Submission link http://majorprojects.planning.nsw.gov.au/index.pl?action=view_job&job_id=9579

Concept State Significant Development Application – SSD 18_9579 Crows Nest Overstation Development - Submission

Hume Street Park		Willoughby Road		Ernest Place, Crows Nest Community Centre and Holtermann St Carpark	
Overall size	1,0872m2	%	5,901m2	%	4,846m2	%
3:45pm	358m2	3.29	594m2	10.06	3m2	0.06
4:00pm	365m2	3.35	509m2	8.62	516m2	10.64
4:15pm	229m2	2.1	373m2	6.32	1441m2	29.73

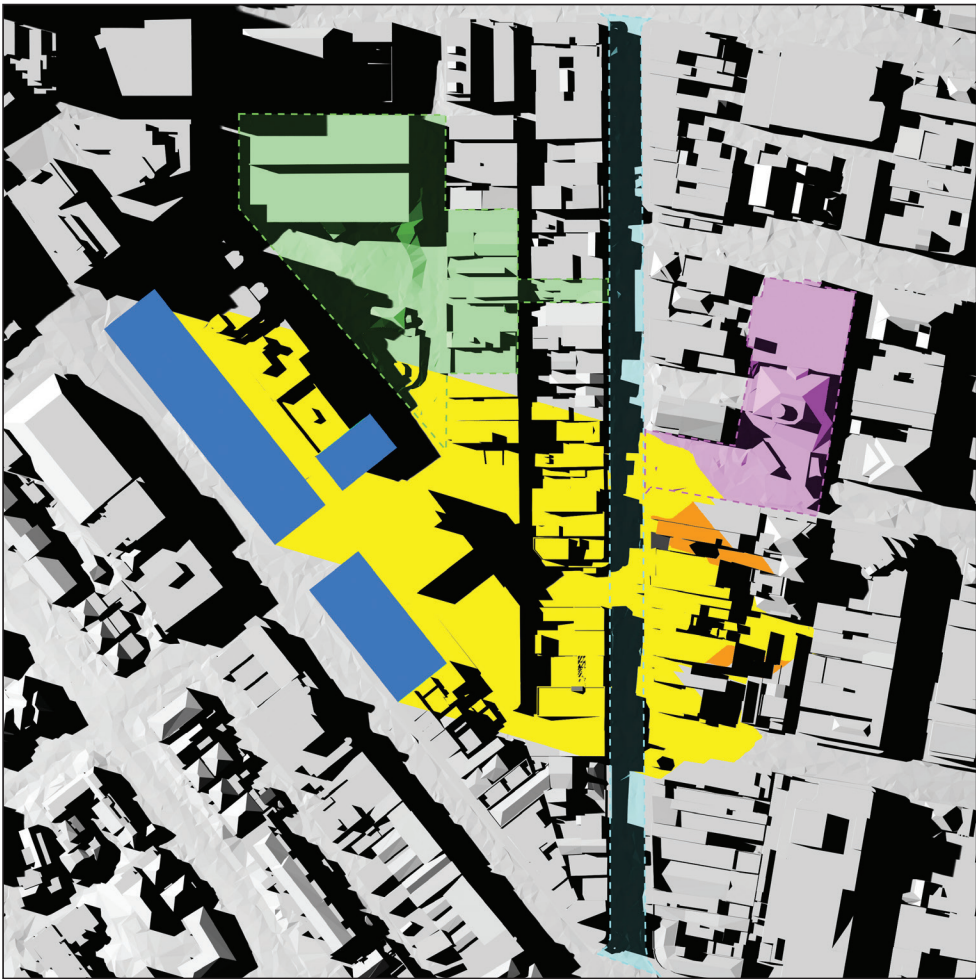
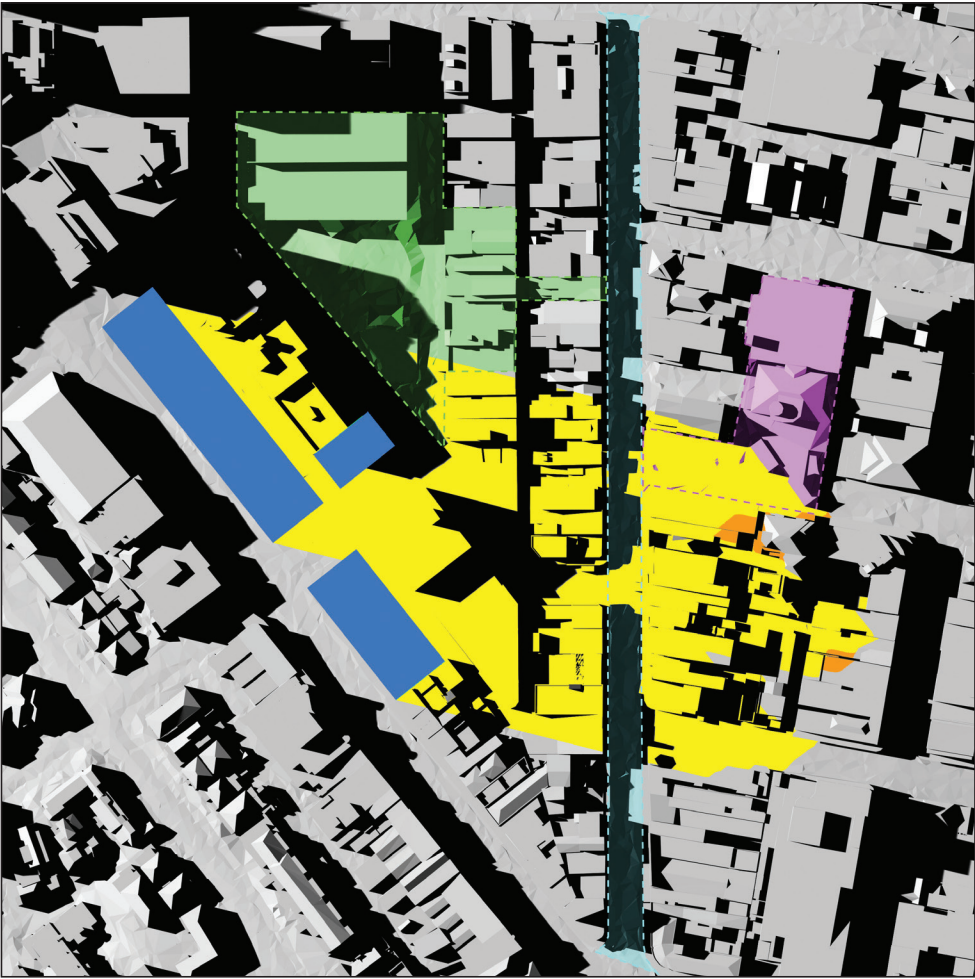
- I object to the overshadowing of Nicholson Street, Hume Street Park, Willoughby Road and Ernest Place in particular year-round, not just between 9.00 am and 3.00 pm.
